30<sup>th</sup> September 2014

**Planning Applications 3/2014/0783 & 3/2014/0791 Change of use to form en-suite letting rooms at Downham Post Office and Ash Tree Cottage, Downham.**

Drawing Title
PROPOSED FLOOR PLANS

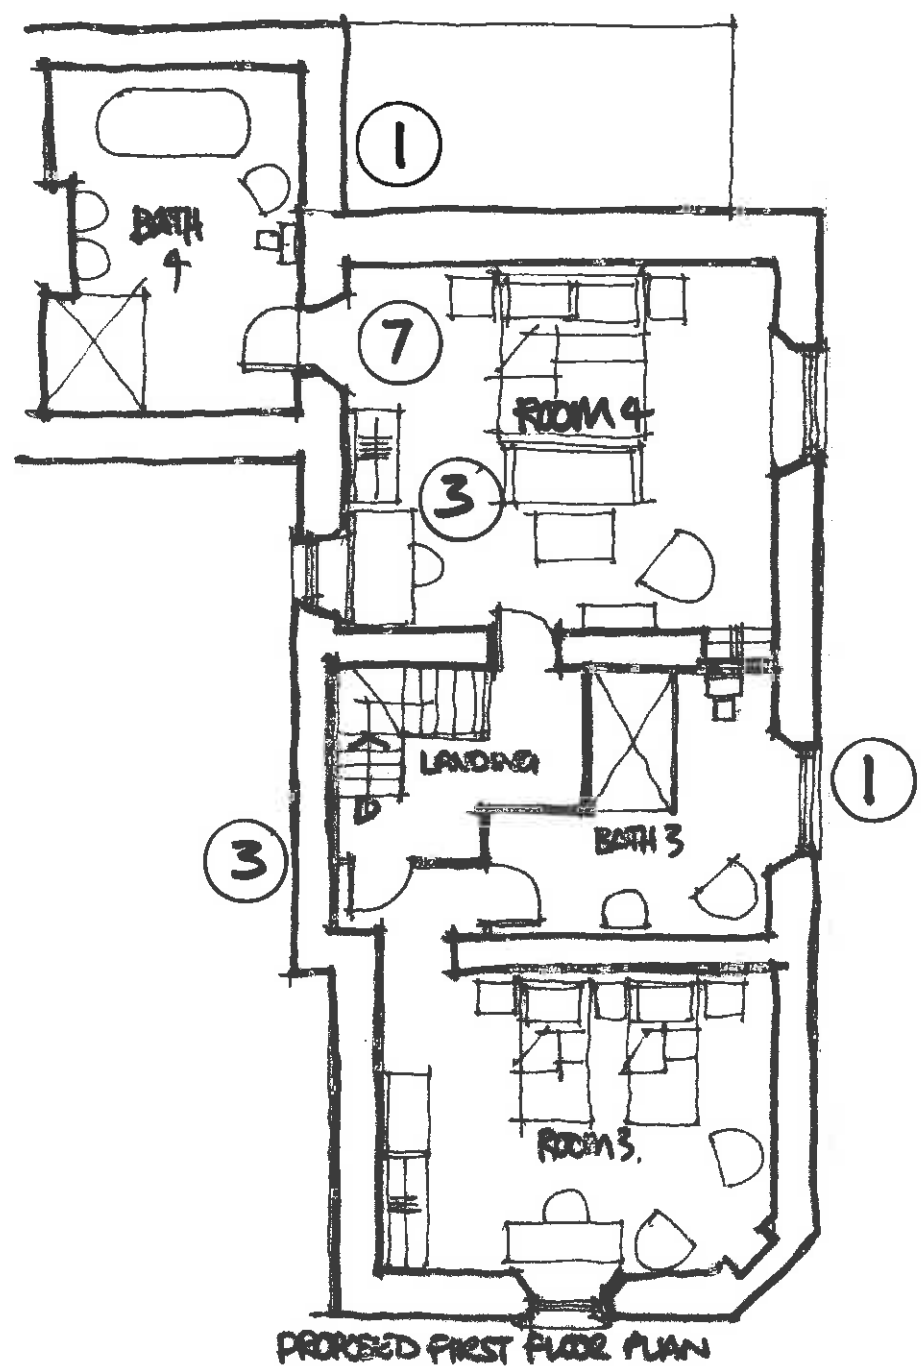
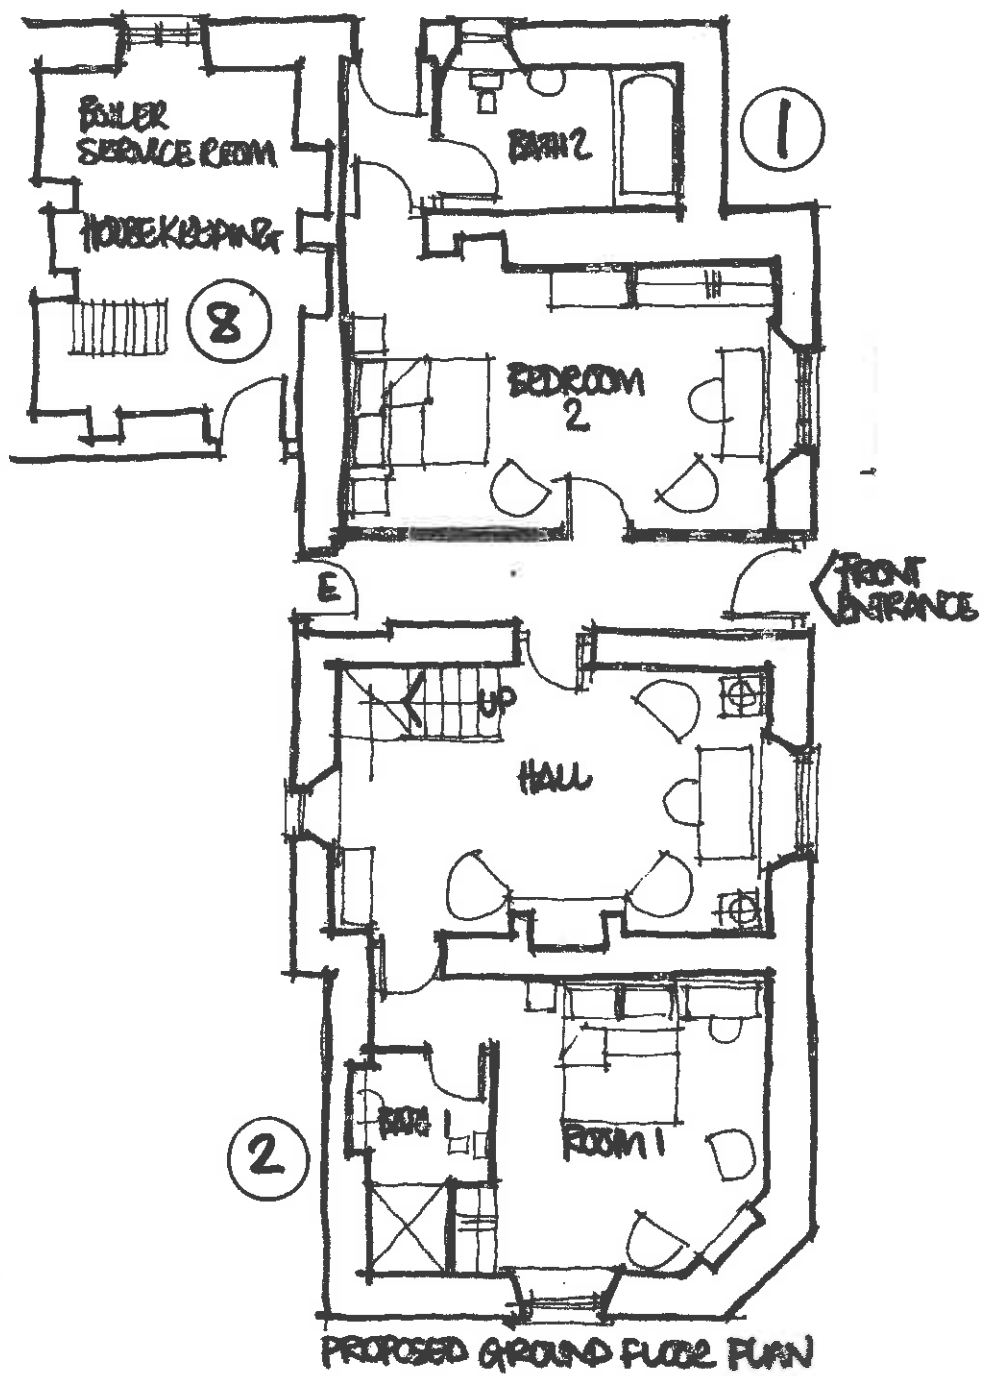
- \* The rooms should be secured with adequate locking mechanisms to reduce the risk of crime in periods when they are not being used.
- \* Low energy dusk to dawn lighting should be installed at all external doors and in the courtyard areas to enhance natural surveillance within the hours of darkness. The lighting would also promote safe use and encourage feelings of safety for users.
